CITY OF ALBUQUERQUE

March 14, 2019

Re: T&M self storage
2301 Vista Oriente Street NW
Traffic Circulation Layout
Engineer's/Architect's Stamp **03-12-2019** (H10D033)

**TRAFFIC CIRCULATION PLAN**

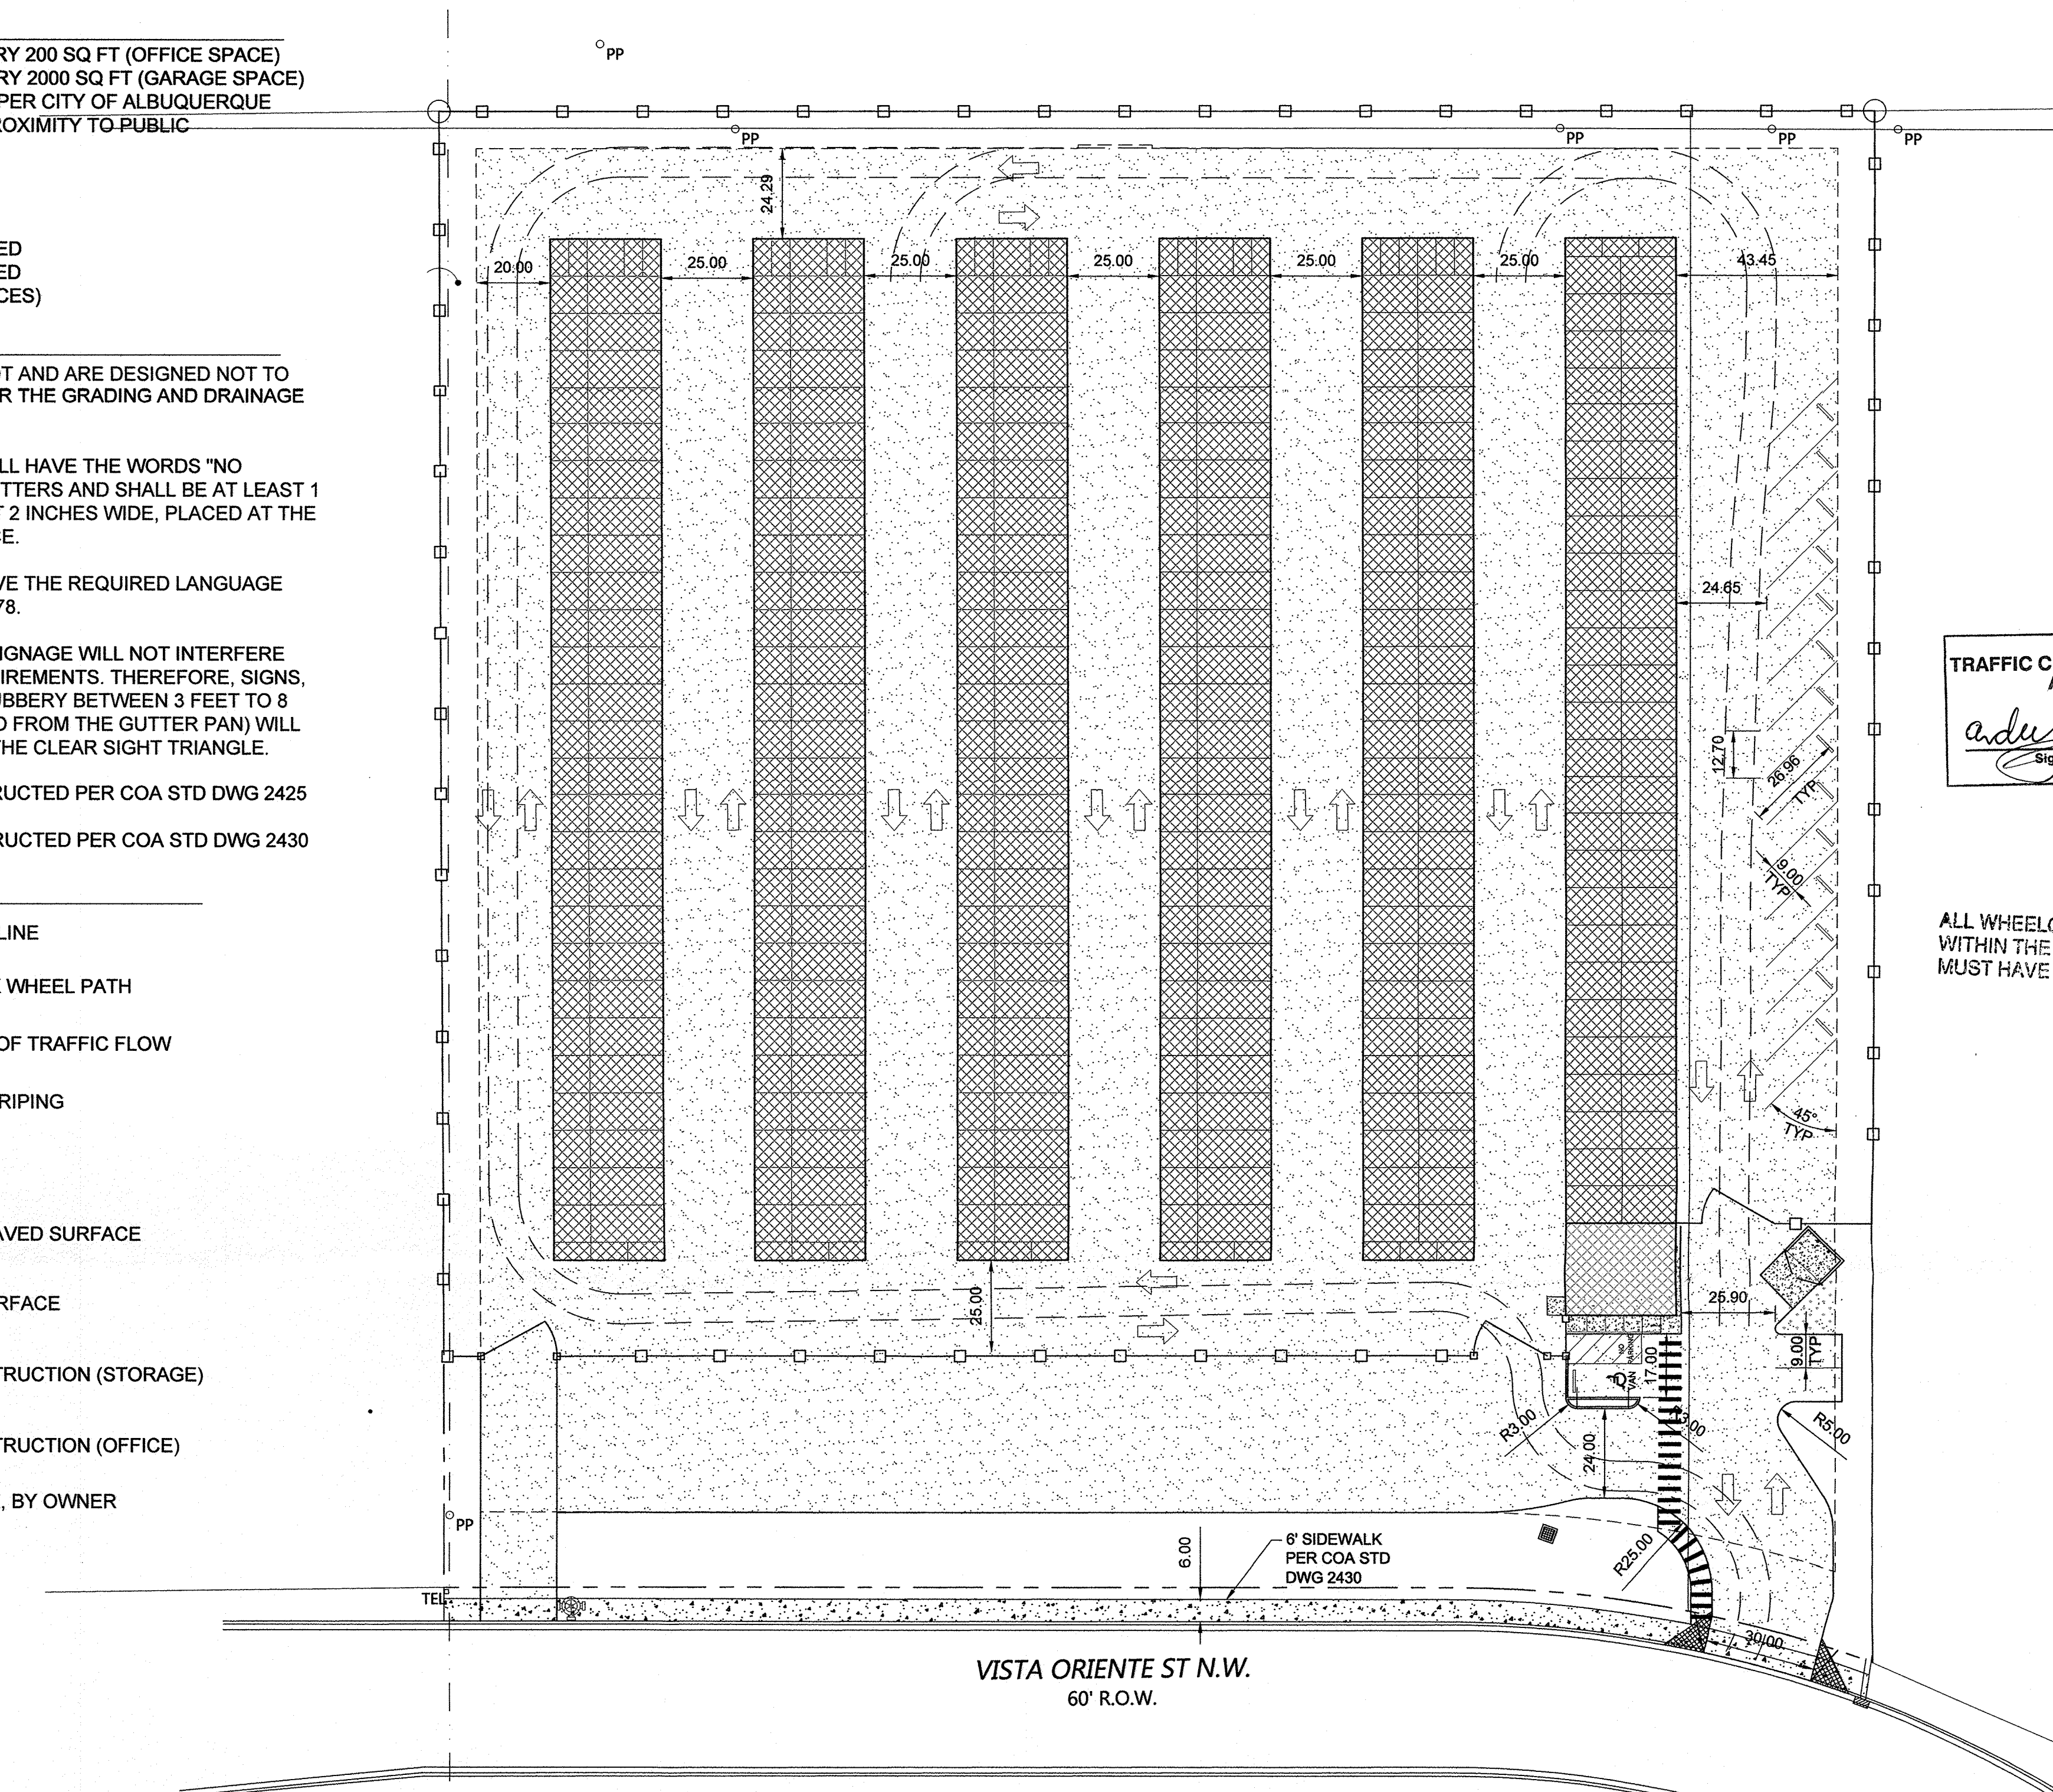
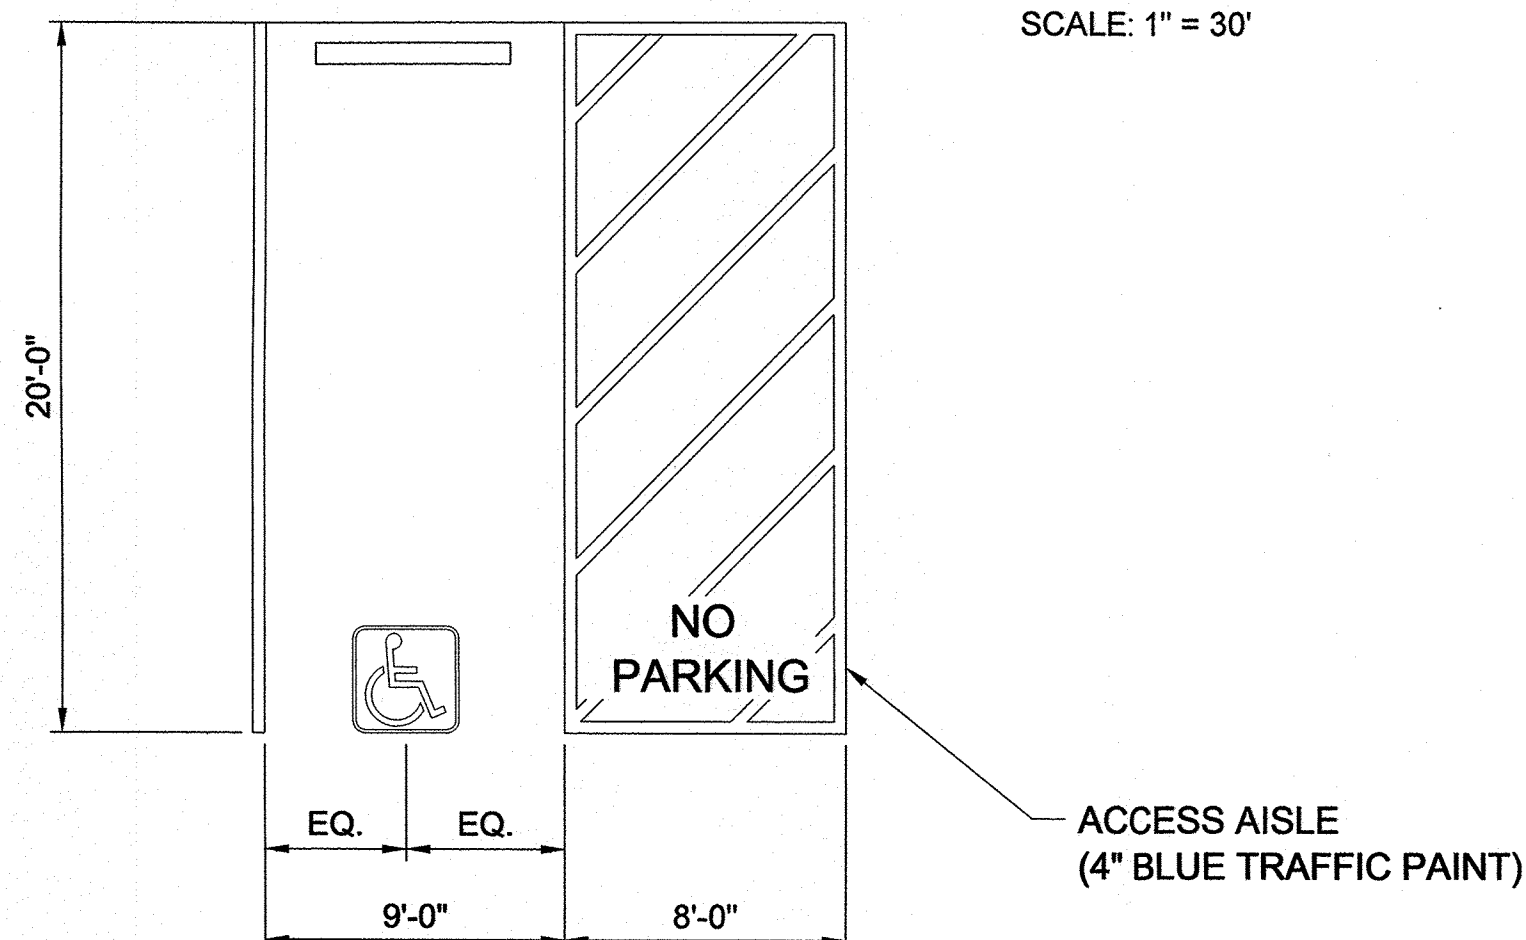
1. The handicap accessible spaces must include an access aisle. Van accessible aisles should be 8ft wide; all others should be 5ft wide.
2. The ADA access aisles shall have the words **"NO PARKING"** in capital letters, each of which shall be at least one foot high and at least two inches wide, placed at the rear of the parking space so as to be close to where an adjacent vehicle's rear tire would be placed. (66-1-4.1.B NMSA 1978)

3. It is not apparent how the ADA access isle is connected to the side walk
4. Show all drive aisle . Some dimensions are not shown.
5. What is the square piece that is hatched red. Is that an office?

6. Per the zoning code, a 6 ft. wide ADA accessible pedestrian pathway is required from the public sidewalk to the building entrances. Please clearly show this pathway and provide details.

7. Show the clear sight triangle and add the following note to the plan: "Landscaping and signage will not interfere with clear sight requirements. Therefore, signs, walls, trees, and shrubbery between 3 and 8 feet tall (as measured from the gutter pan) will not be acceptable in the clear sight triangle.
